**RE: MAPES SHORT PLAT, File Number SP-07-49**

Kittitas County Community Development Services has determined that the Mapes Short Plat is a complete application and hereby grants **conditional preliminary approval** subject to the following conditions:

MAPES SHORT PLAT
PART OF SECTION 27, T. 17 N., R. 19 E., W.M.
KITITAS COUNTY, WASHINGTON

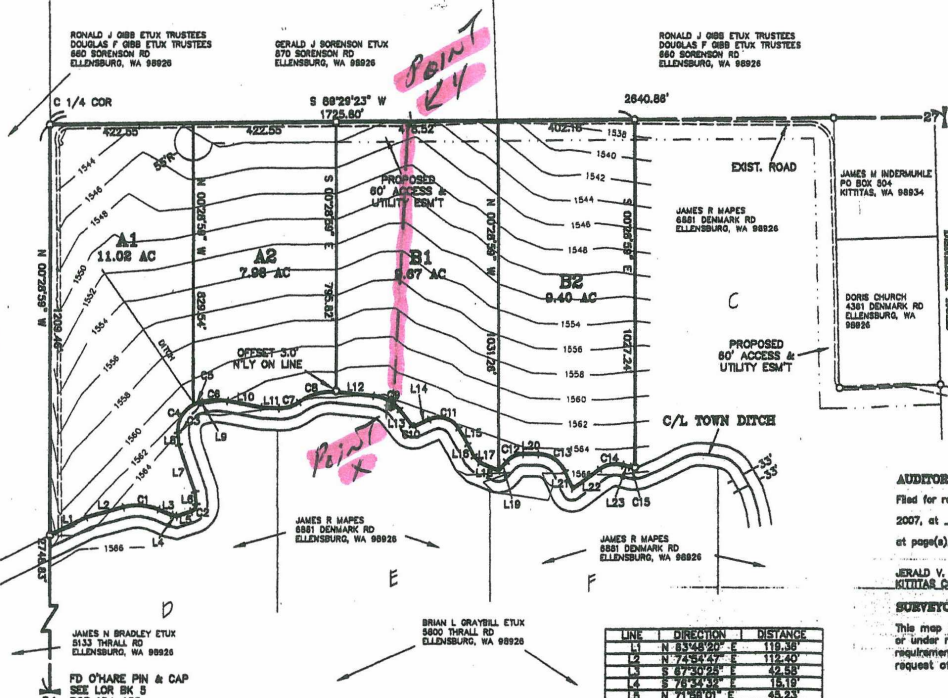
1. Both sheets shall reflect the short plat number **SP-07-49**.
2. Refer to Kittitas County Code Title 16 for requirements for final plat submittal. Final mylars shall be submitted per KCC 16.20: Final Plats.

3. All existing easements shall be clearly delineated and labeled on the final mylars.
4. This property is within the boundaries of the Ellensburg Water Company and all 4 parcels contain irrigable ground. The applicant will need to comply with the requirements set forth in the Minutes of Special Meeting of Board of Trustees of Ellensburg Water Company prior to approval from Ellensburg Water Company and prior to final approval of the short plat.

5. The following notes shall appear on the final mylar:
  - Ellensburg Water Company operations and maintenance roads are for Company use only. All other uses, including residential and recreational use is prohibited.

- According to Ellensburg Water Company records, Lot A1 has 11.02 irrigable acres, Lot A2 has 7.98 irrigable acres, Lot B1 has 9.67 irrigable acres, and Lot B2 has 9.40 irrigable acres.

6. The subject parcels are located within the AG-20 zoning district. The following plat note shall appear on the final mylar:
  - This short plat has exhausted the use of the one-time split provision allowed per Kittitas County Code 17.29.040. No further one time splits are allowed for the subject parcels and subsequent parcels created via this
